Morgan and Morecambe Offshore Wind Farm: Transmission Assets

**Appendix B5 to Natural England's Deadline 5 Submission**  
**Natural England's comments on Physical Processes and Benthic Subtidal and**  
**Intertidal Ecology**

Planning Inspectorate Reference EN020028

22 September 2025

Figure 3: Indicative Beach Working Areas for Trenchless Installation Works

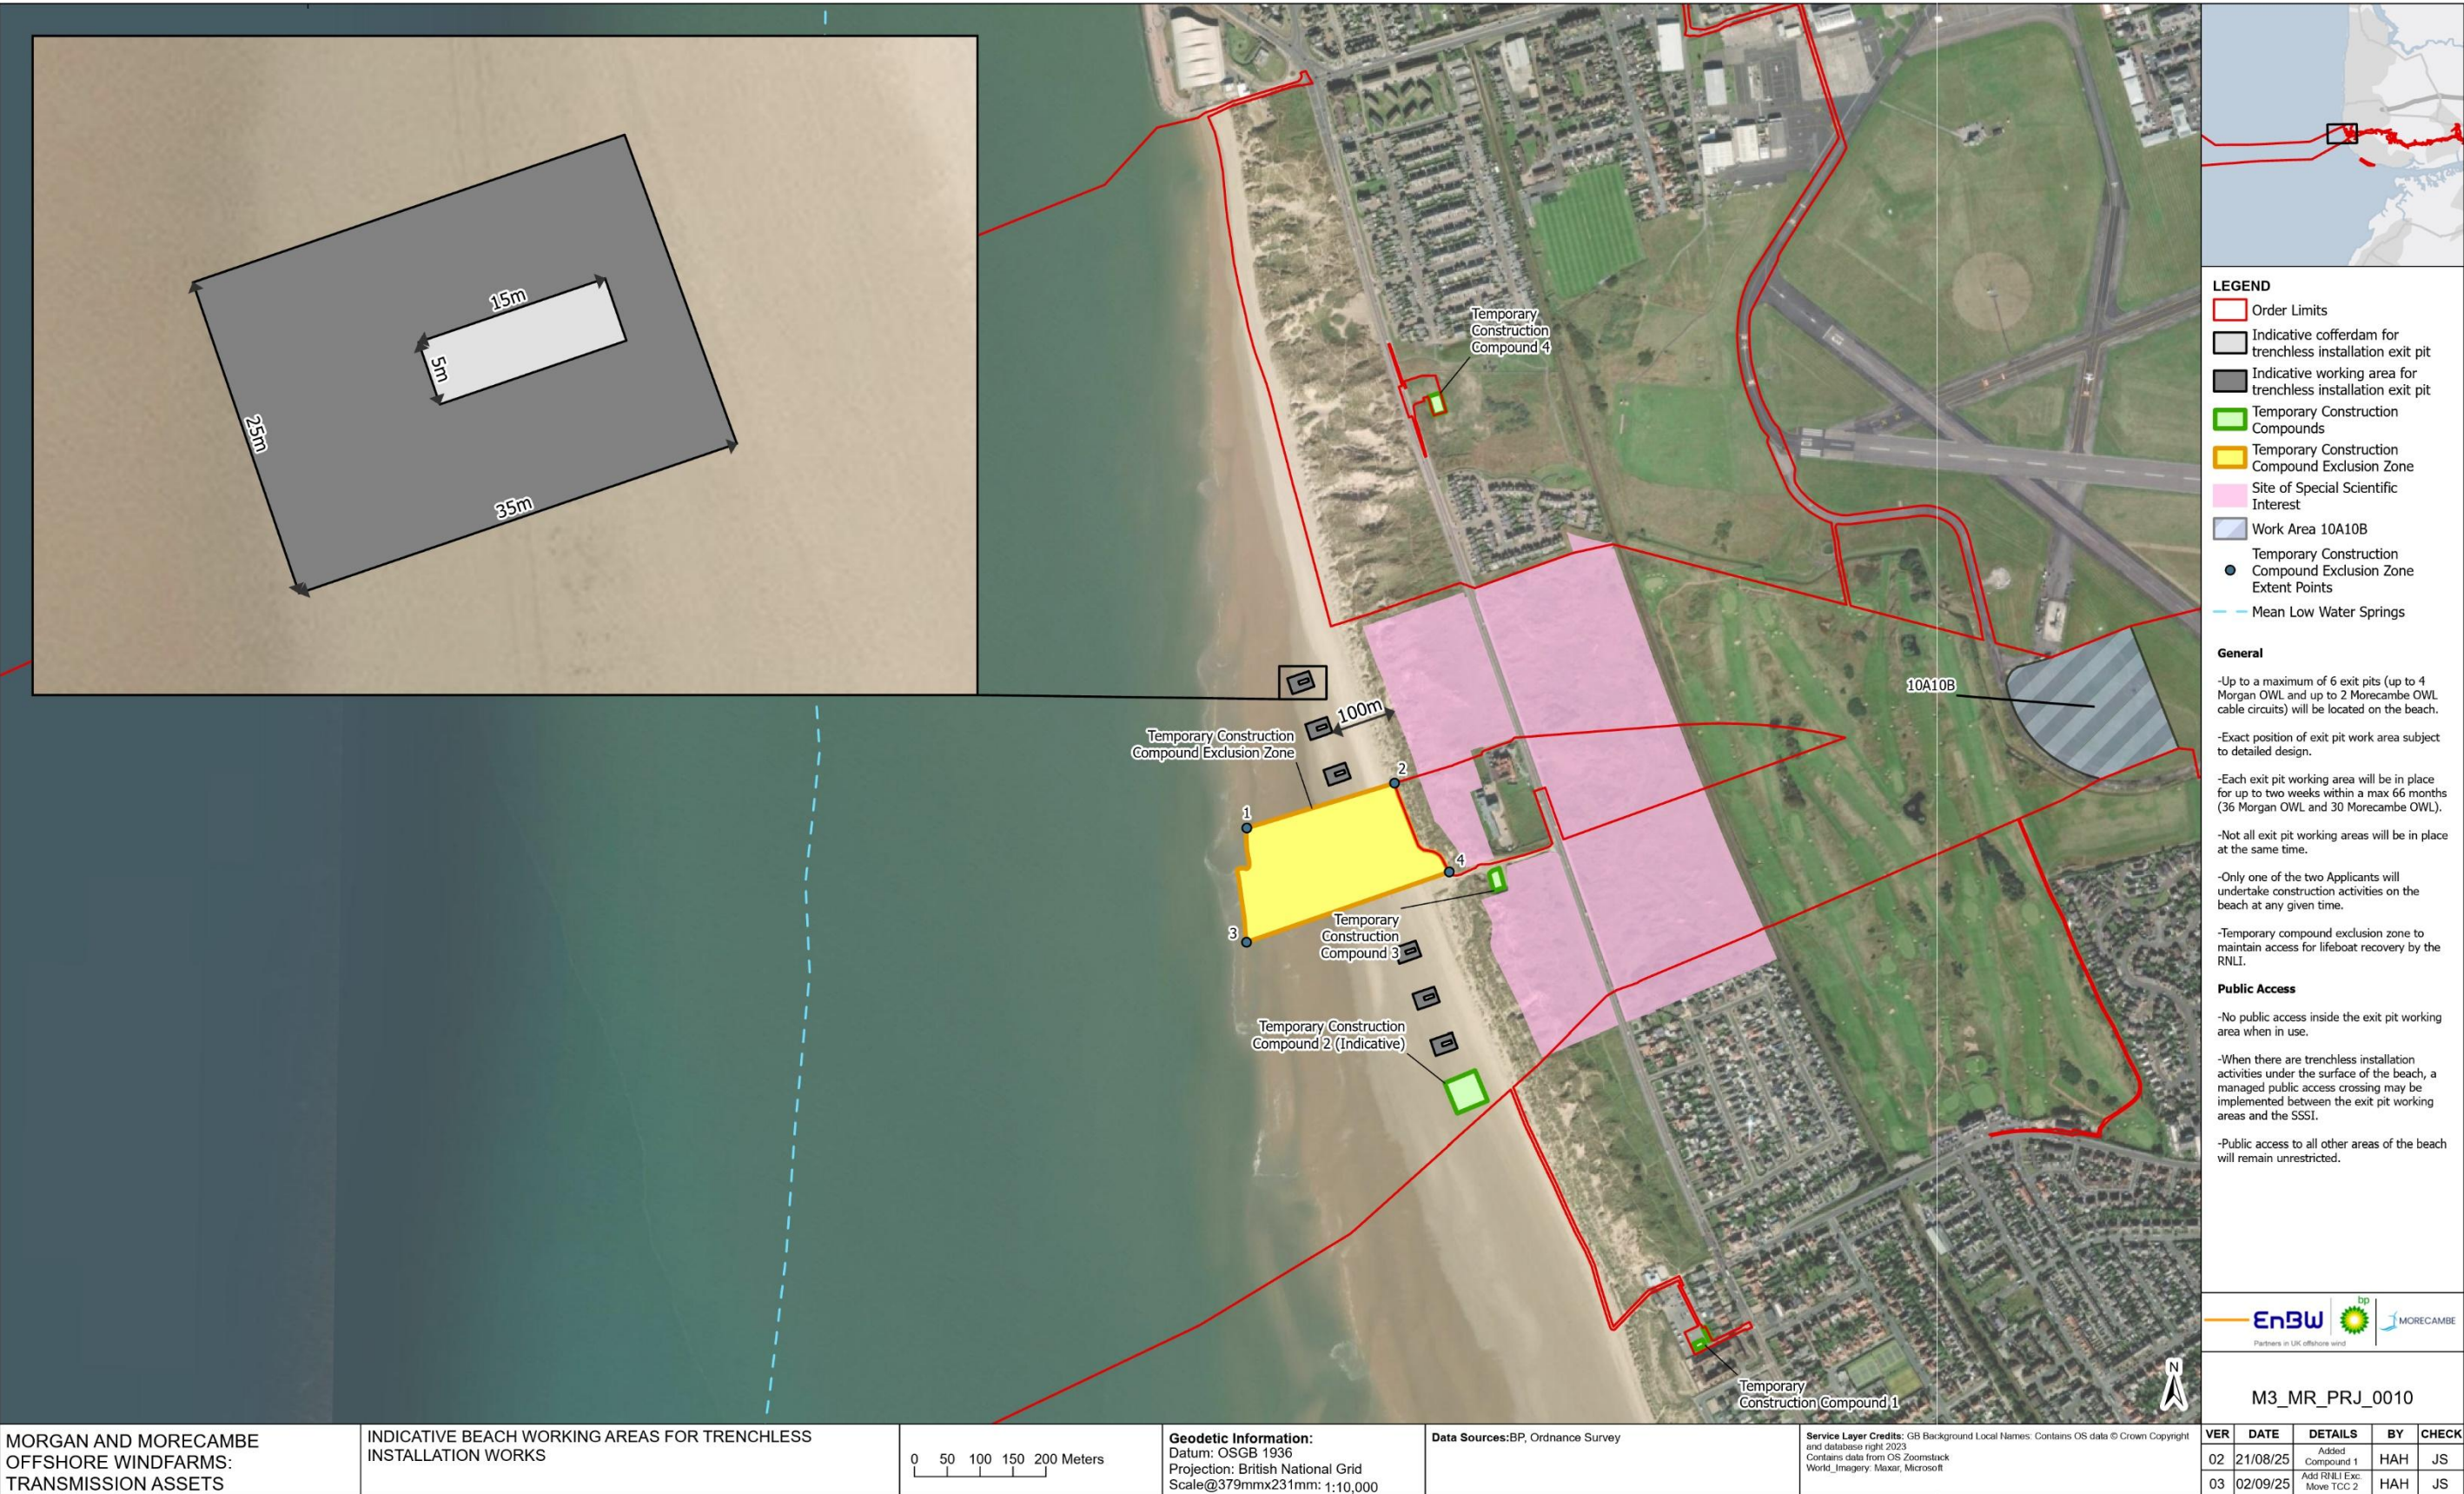
3	Figure 3, (p20)	Natural England notes that limited information is provided as to where the excavated material from 6 exit	Natural England advises that further information is required regarding where excavated sediment will be stored and how this has informed the coastal processes impact assessments.

pits shown in fig 3 (p20) will be stored. It is also not clear how this may/may not impact on coastal processes.	
4	1.13.5.3	Natural England notes that this section states the TJBs will be infilled with a mixture of cement bound sand and previously excavated material. However, there is limited information provided in relation to why the cement is required, the depth of deployment and consequences of making this area less resistant to both vertical and horizontal erosion and whether sufficient sediment will remain to infill the excavated areas.	Natural England advises that a further impact assessment is required on the use of cement bound sand. We highlight that this is included as a new issue within our R&I log.
5	1.13.6	A variety of machinery is listed in this section as being needed for landfall construction. Vehicles and trampling can severely damage sand dunes by destabilising them, compacting soil, destroying vegetation and altering dune morphology.	<p>Onshore plant and vehicles and use of the site by construction workers need to comply to best practice.</p> <p>The following list of mitigation measures are known to reduce the impacts of construction works when working in sensitive habitats which should be added to this method statement:</p> <ul style="list-style-type: none"> <li>• All vehicles and personnel should follow agreed access routes</li> <li>• All site staff/ contractors should all be briefed as to the importance of the site/ habitat via a tool-box talk when they start working on the project; a record of who has had this briefing should be kept.</li> <li>• Restrict staff numbers on site to minimum effective levels.</li> <li>• Welfare facilities and storage of materials should be positioned away from the designated area</li> <li>• Contingency planning prior to works commencing to understand what the process would be to retrieve broken down vehicles/ machinery.</li> <li>• Signage should be used to inform the public of the sensitivities of the site during construction.</li> <li>• Strict pollution control measures should be followed, following industry good practice.</li> </ul>
